Rezoning Transportation Analysis

Petition Number: 2022-198

From: Jake Carpenter, PE
Jacob.carpenter@charlottenc.gov
980-221-5675

Reviewer: Patrick Monroe
Patrick.Monroe@charlottenc.gov
704-301-1411

RZ-2

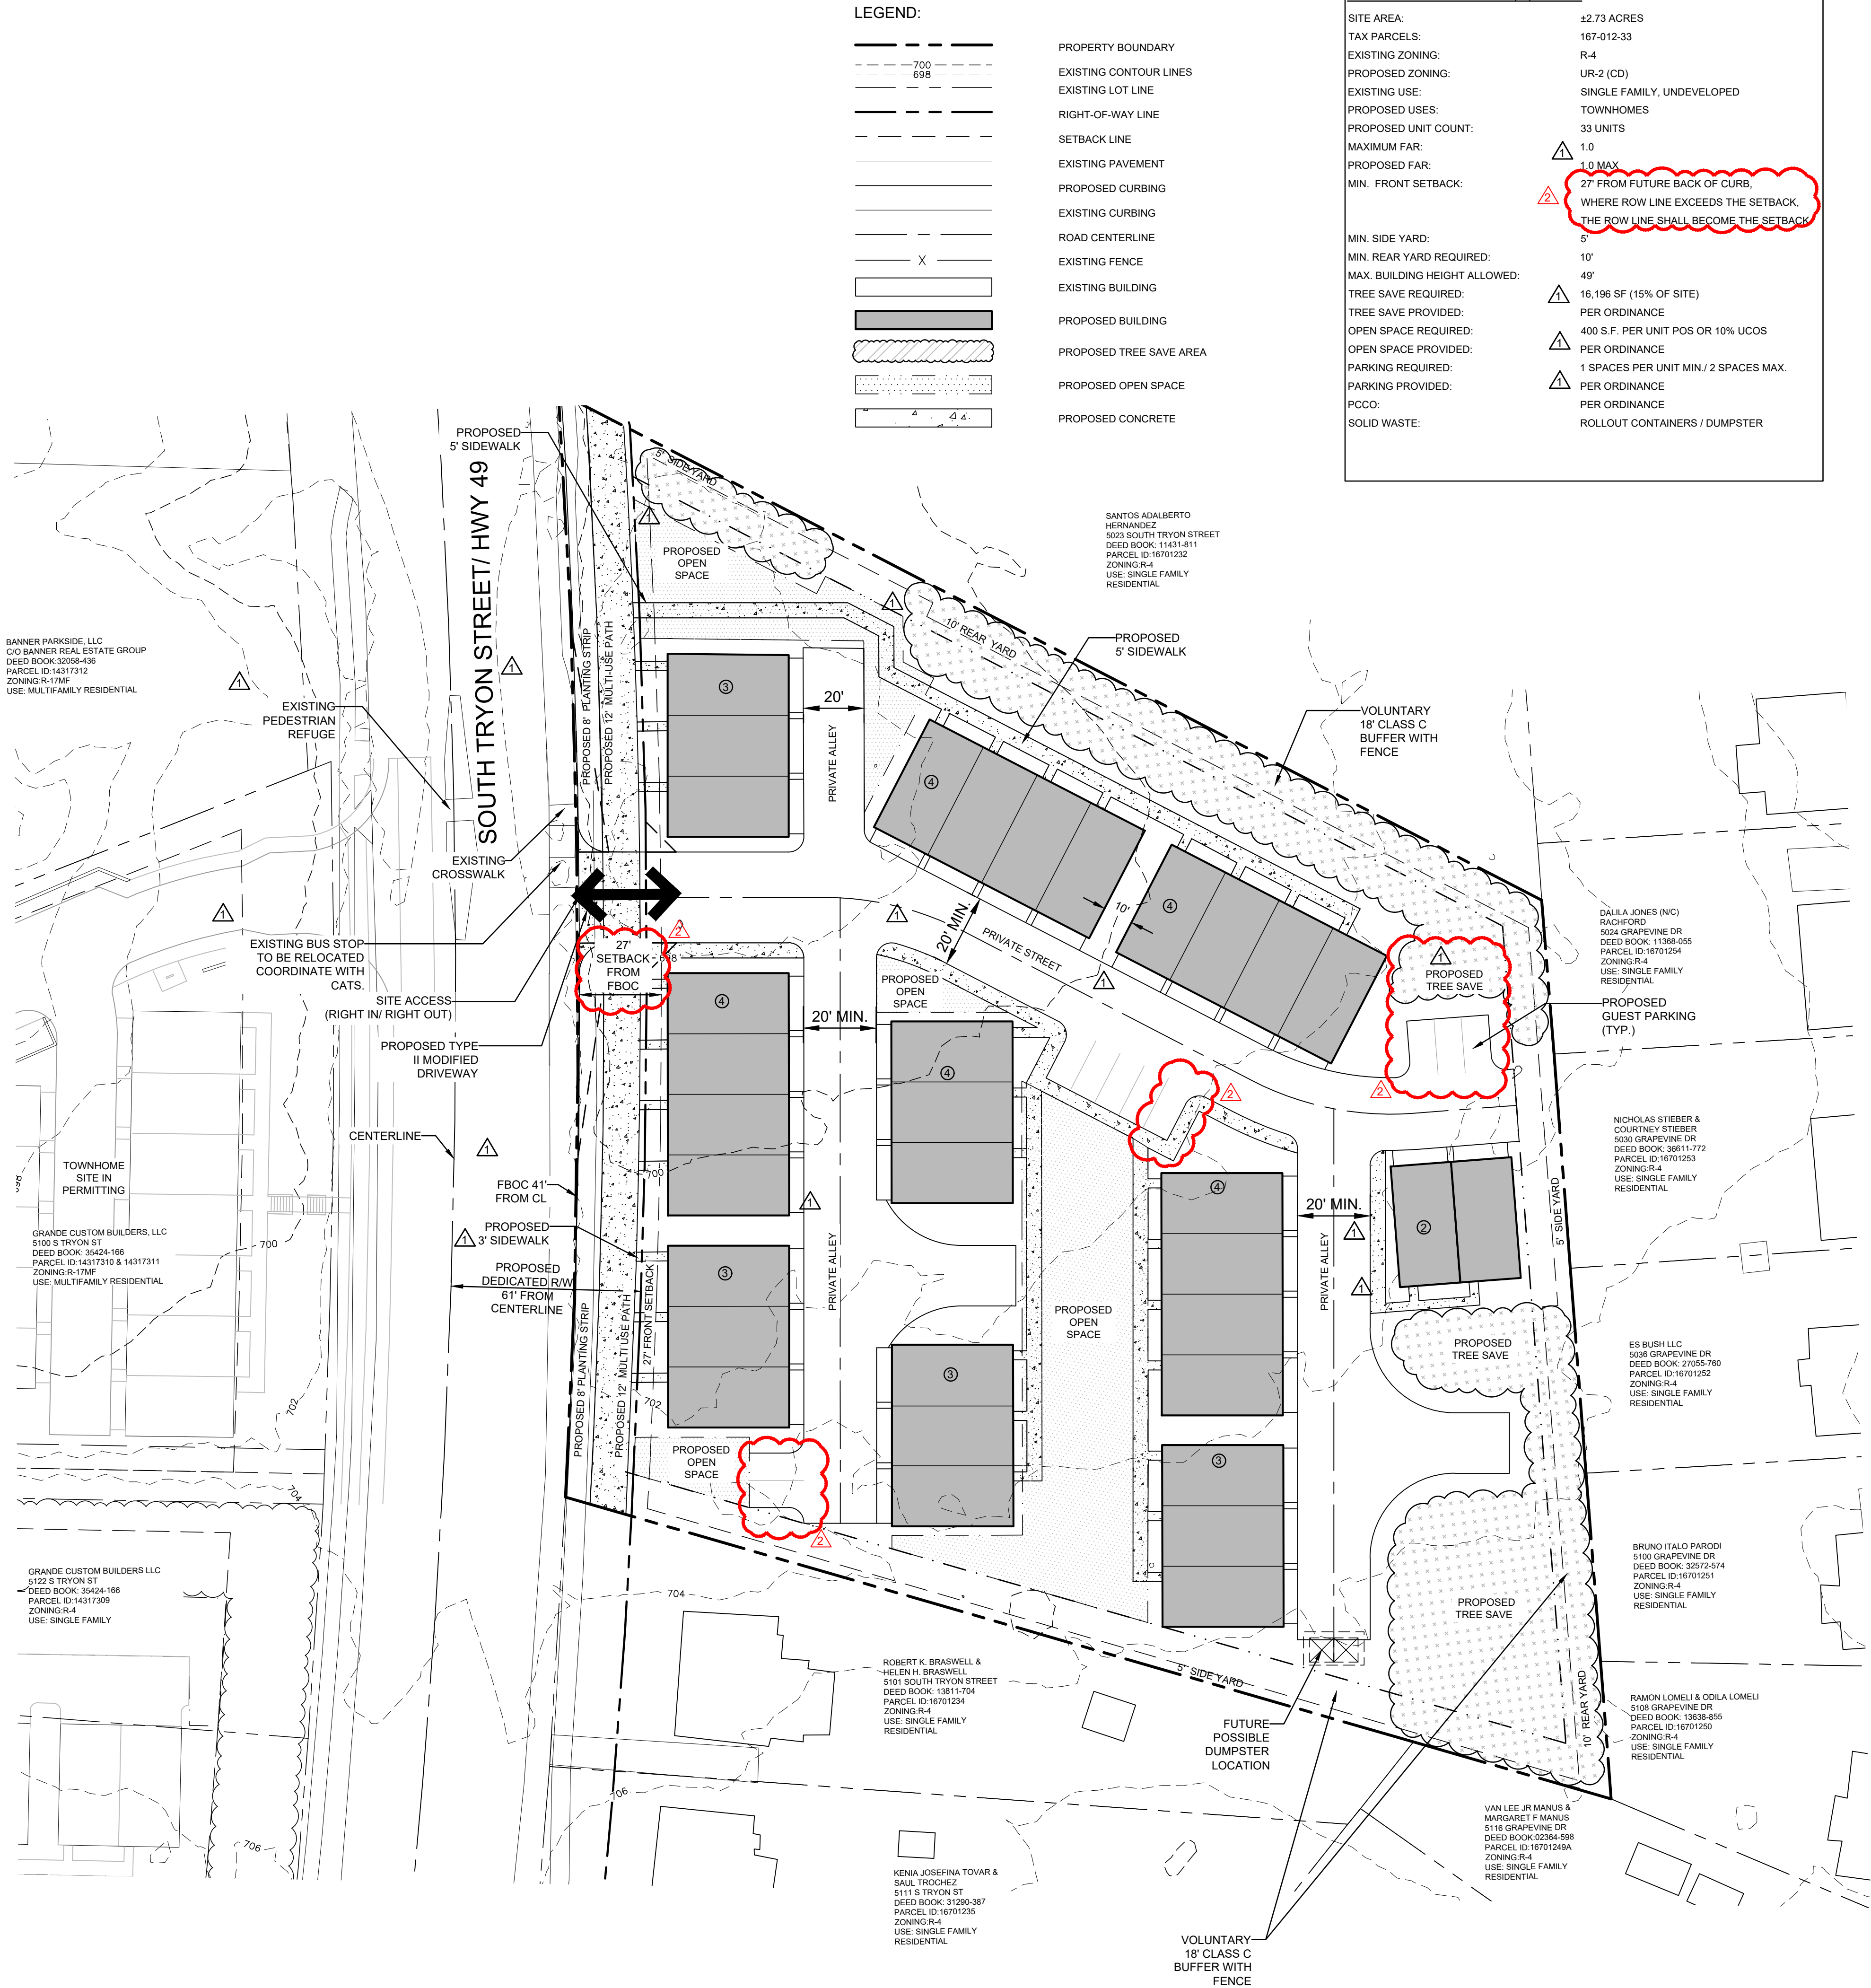
~~**South Tryon Street:** Future location of curb and gutter to be located 41 feet from roadway centerline to accommodate the Charlotte Streets Map with a roadway typical section of a 6+ Avenue~~

~~Label and dimension the curb and gutter from the centerline for each road on the site plan.~~

~~3. Revise site plan and conditional note(s) to commit to construct bicycle facilities by locating installing a 12' multi-use path to meet the Council-adopted Charlotte BIKES Policy. Multi-use paths maintained by the City shall meet ADA/PROWAG requirements.~~

- ~~5. Revise site plan and conditional note(s) to show the existing pedestrian refuge/crosswalks and the bus stop.~~
- ~~6. Revise site plan and conditional note(s) to label the street classifications of all internal streets and whether they are public or private.~~

- ~~7. Revise site plan and conditional note(s) to identify the proposed site access as right in / right-out.~~
- ~~8. Add a conditional note specifying "the Petitioner shall dedicate and convey in fee simple all rights-of-way to the City before the site's first building certificate of occupancy is issued. CDOT requests rights-of-way set at 2' behind back of sidewalk where feasible."~~

Outstanding Comment 5.24.2023: Remove the highlighted portion of the comment below.

8. All transportation improvements required to be constructed by Petitioner under this Section C of the Development Standards will be approved and constructed prior to the issuance of the first certificate of occupancy for a new building constructed on the Site.
